REVIEW COMMENTS

Project:		NM 335.01 Gibson & 98th St Gas Station		PDE:		
Review:				Reviewer:		
Date:		12/12/2022		Matt Grush, P.E.		
#	PAGE	SECTION	COMMENT	AGENCY	STATUS	RESPONSE
1	2	Introduction (Figure 1)	Locate Driveway B as far east as practicable. This will improve the access to the westbound leftturn lane at 98 th St and provide space for future lengthening of the right-turn lane.	COA	Agree	Accepted see new site plan included as Figure 1
2	2	Introduction	Relocate Driveway A to the north limits of the development	COA	Evaluate	The location of driveway A is fixed as an existing access point. This access point is an existing access easement.
3	48	Development Site-Specific Observations and recommendations	Add a right-turn lane [Driveway A], the length may be less than the DPM requirement. The City may accept a reduced length of the turn lane. Provide a short discussion on the effectiveness of the modified turn lane.	COA	Agree	A right-in / right-out driveway with a right-turn deceleration lane has been added to the site plan located south of driveway A. A discussion of the deceleration's effectiveness has been added to the body of the report.

PEDESTRIAN ACCESS TO WALKWAY
SCALE: 1" = 10'

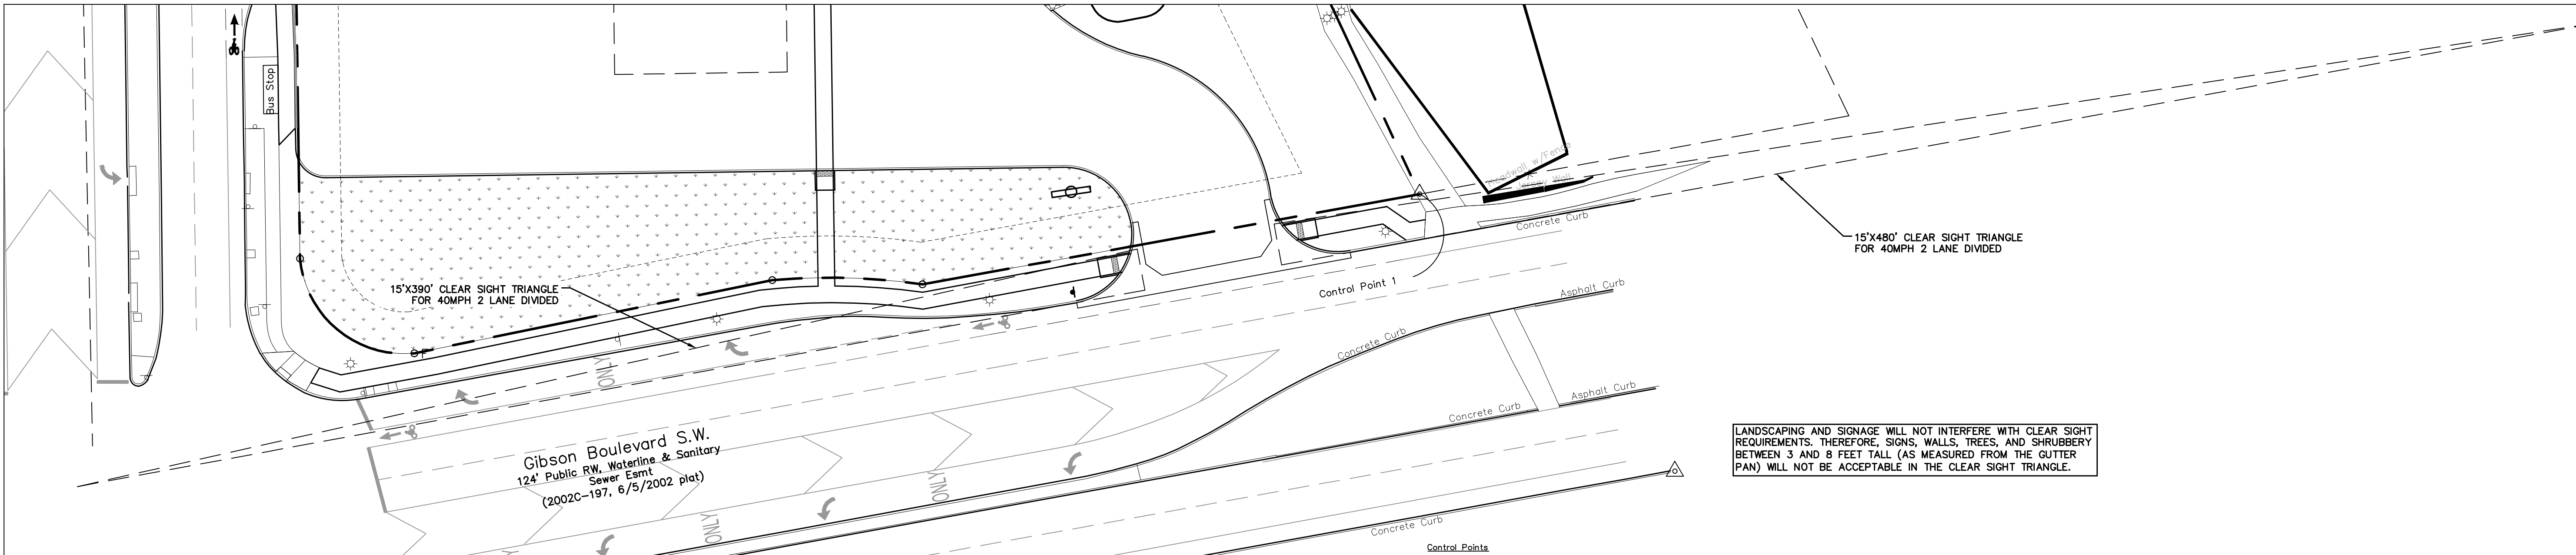
4	2	Introduction (Figure 1)	The transit stop should remain as is. The northbound right-turn lane can begin immediately north of the transit shelter.	COA	Agree	Accepted: This configuration is reflected in the newest site plan included as Figure 1
5	2	Introduction, Development Site-Specific Observations and recommendations	The access to the PNM facility should remain. Add a notification sign that this driveway is for PNM access only/dead end or what you feel is needed to discourage erroneous use of this driveway. The developer should coordinate with PNM concerning this driveway.	COA	Agree	No-Right turn sign added to driveway.
6	3	Summary of Recommendations	Summary of recommendations on page 3 describes Driveway A as right-in only. The analysis has this as a partial right-in/right-out. Please correct this to be a partial right-in/right-out access	COA	Evaluate	The summary of recommendations describes Driveway A as a Full Access driveway. The developer has since added a driveway to function as a right-in / right-out south of Driveway A on 98th St. This configuration change would make Driveway A a Left-in/ Left-out access point. Signing for both Driveway A and the new right-in/right-out driveway just south of it is shown in the new site plan shown in Figure 1.
